## City of Albuquerque Stormwater Construction Site Inspection Report

General Information					
Project Name:	Top Golf				
Location:	1600 Desert Surf				
Site Contact Name & Agency	Richard Breck/ Troy Manwill - Arco	ESC File No.	F16E003E1		
	<a href="mailto:rbreck@arc01.com">rbreck@arc01.com</a>	NPDES Id. No.	NMR100XF		
Inspection Date:	09/30/19	Start/End Time:	0900/1100hrs		
CoA Stormwater Inspector:	Timothy E. Sims				
Construction Phase:	C&G, site work				
Type of Inspection:	<input checked="" type="checkbox"/> Regular	<input type="checkbox"/> Storm Event	<input type="checkbox"/> Post Storm Event >0.25"	<input type="checkbox"/> 311/Complaint	<input type="checkbox"/> Follow Up

SEDIMENTATION/SILT FENCE WITH WIRE SUPPORT

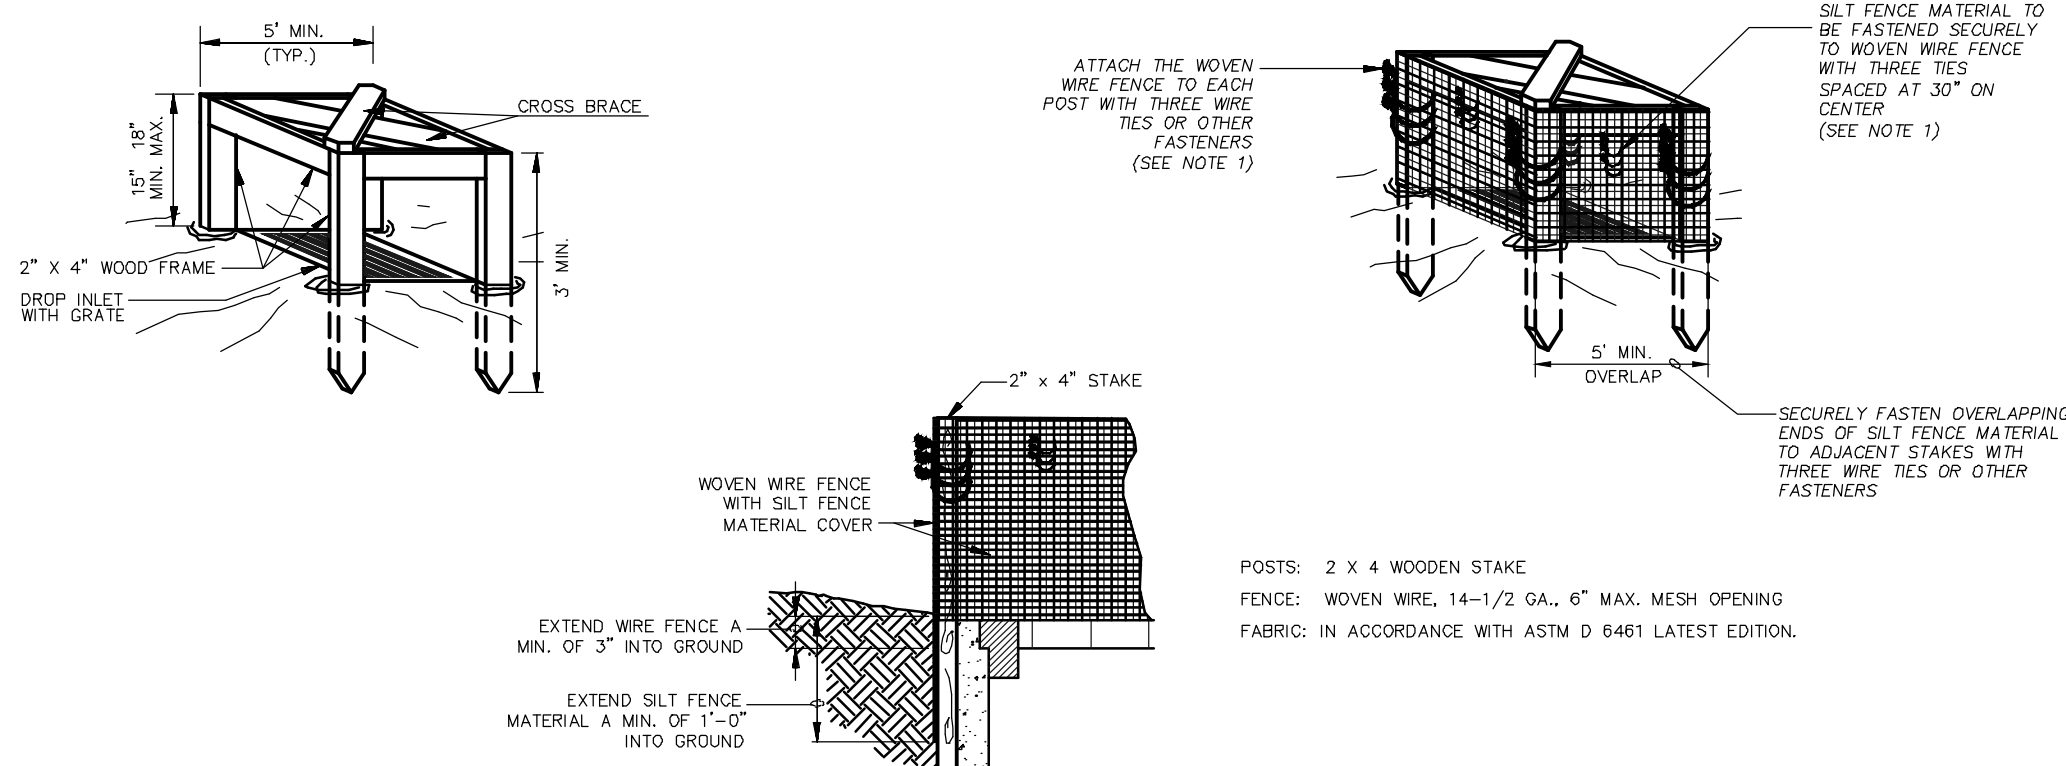
Item Number	Deficiency/ Corrective Action
1	Please provide latest SWPPP self-inspection report
2	Silt fence maintenance is required on silt fence on the perimeter adjacent to the pond requires maintenance. Please mitigate.
3	Massive amounts of sediment in the streets, Desert Surf Circle from Alexander back to Alexander & the access aisle from Desert Surf Circle to the top of the hill (Montano) requires sediment mitigation.
4	Too much erosion is reflected at and around the pond. The slopes are showing signs of erosion also. These slopes are required to be regraded and stabilized.
5	The inlets in Desert Surf Circle requires inlet protection. Please provide inlet protection.
6	Perimeter silt fence has sediment build up that exceeds 50% of silt fence height. Please remove build up on silt fence.
